# City of Albuquerque

October 22, 1981

RE: Industrial Electric Equipment Service Drainage Report Addendum  
Dated September 3, 1981 (File No. J-14-D 9)

INDUSTRIAL ELECTRICAL EQUIPT.				SHEET OF
GRADING AND DRAINAGE PLAN				
ASSBURY & ASSOCIATES CONSULTING ENGINEERS ALBUQUERQUE, NEW MEXICO				
OWNER'S FILE NO. 77-117	DRAWN: D.P. TRACED: D.P.	CHECKED: J.T.A. APPROVED: J.T.A.	DATE: 7/77 SCALE: 1" = 20'

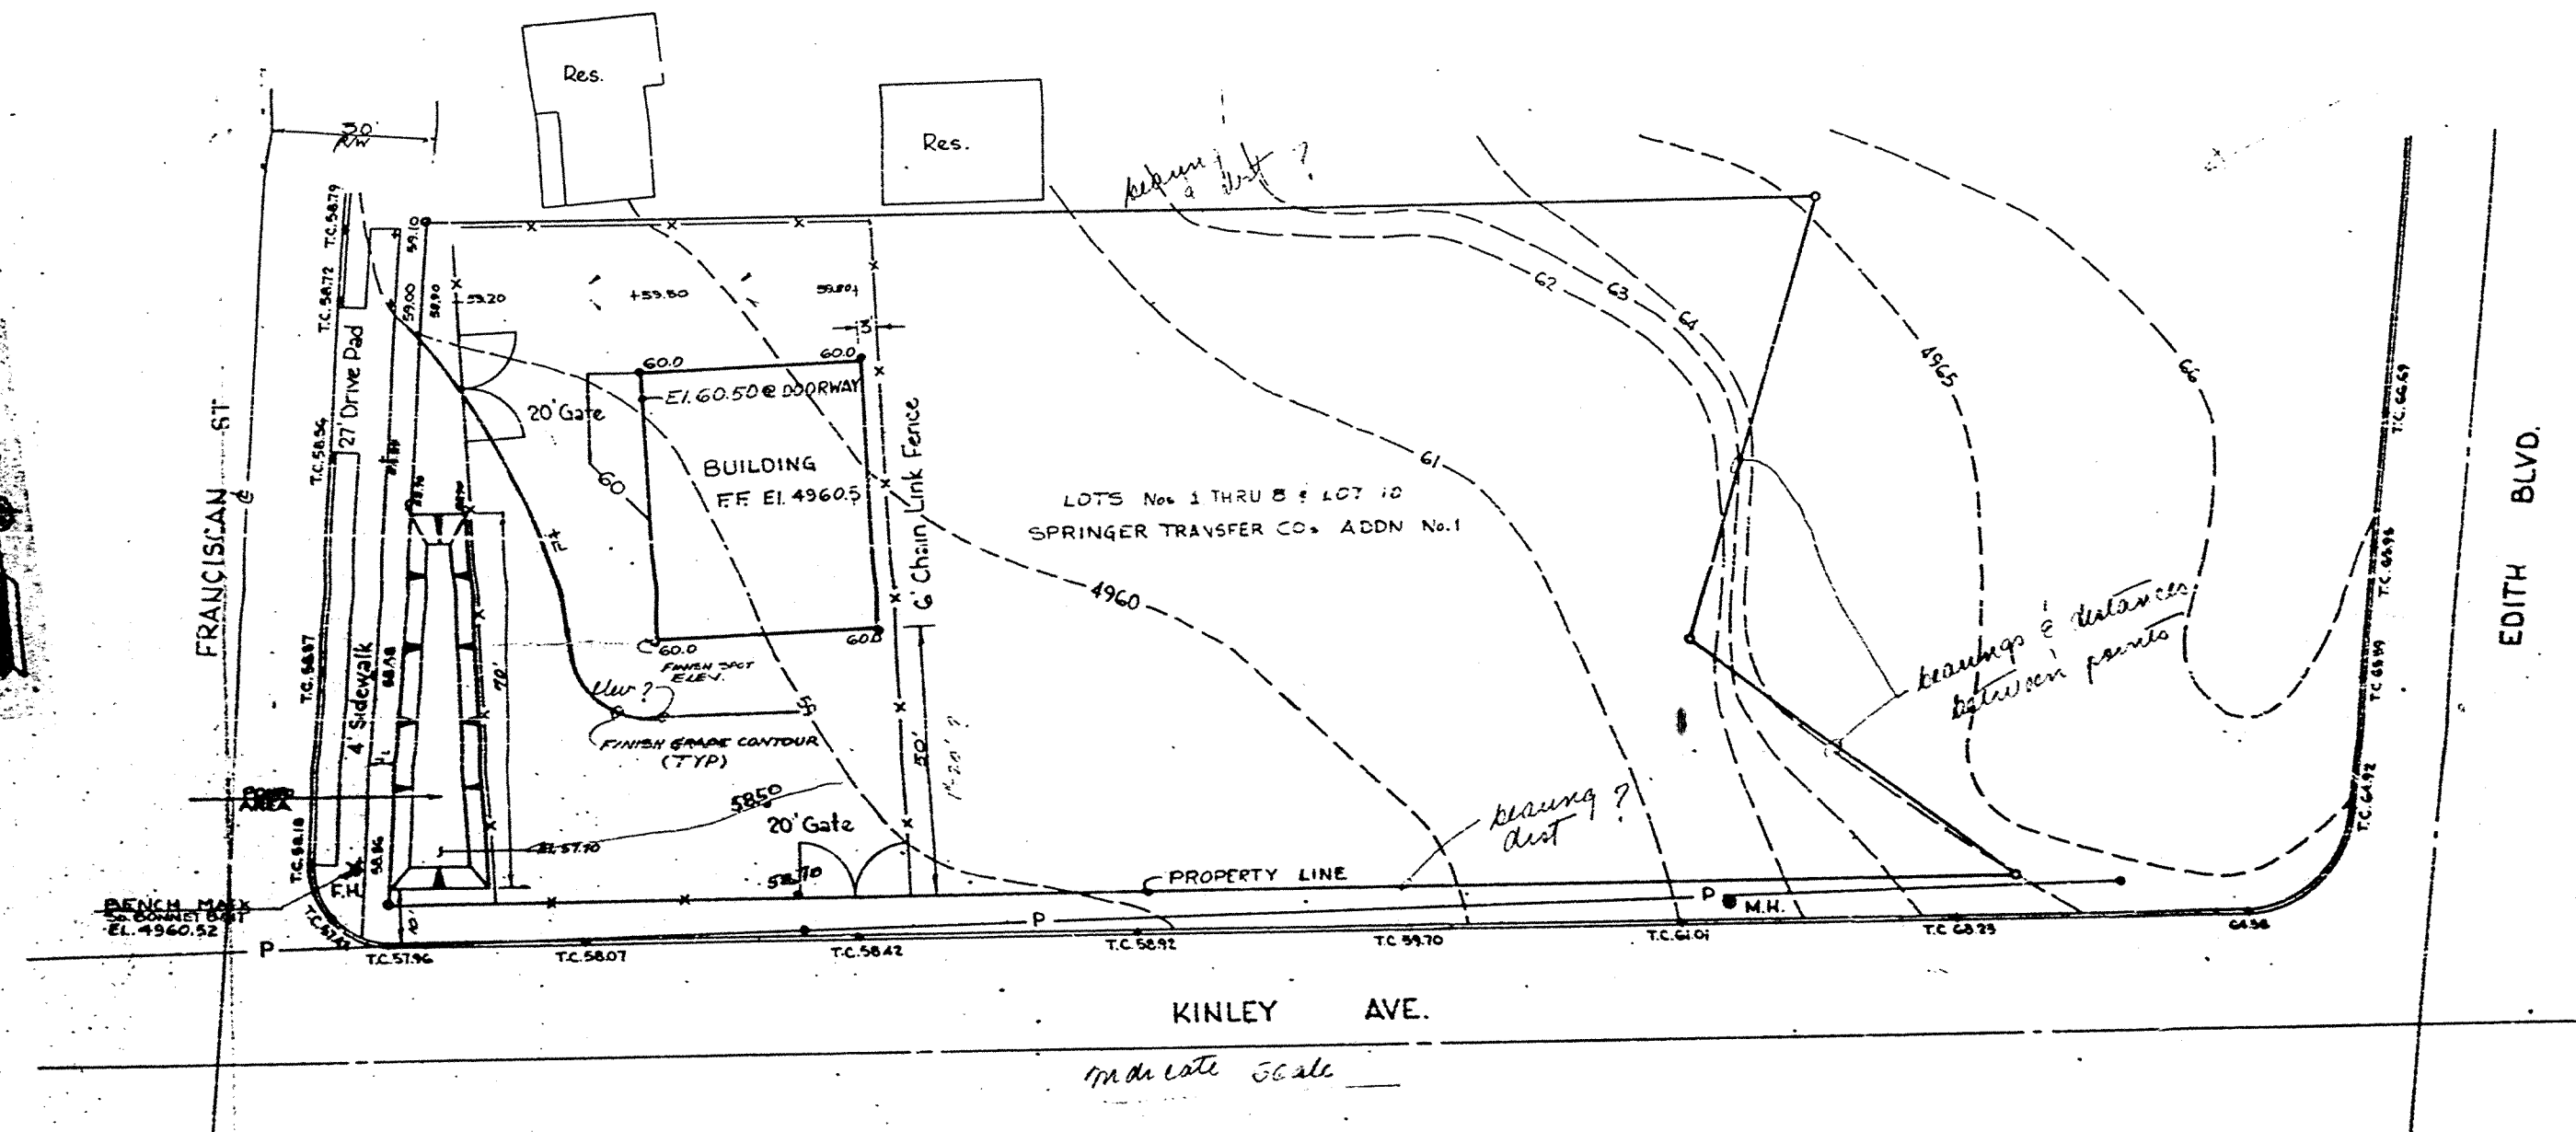
✓ Item 15 B1: Unable to verify pond volumes indicated, please dimension and provide elevations on the cross-sections.

✓ Item 15 B3: Indicate with spot elevations the overflow point for each pond.

✓ Item 21D: Outline on the plan the contributing drainage basin to each pond, including roof areas.

✓ Item 21I: Provide the complete Mean Sea Level designation for the finish floor.

✓ Also, the proposed pond encroachment into City right-of-way requires a completed Encroachment Agreement, otherwise the pond must be located within the property line.
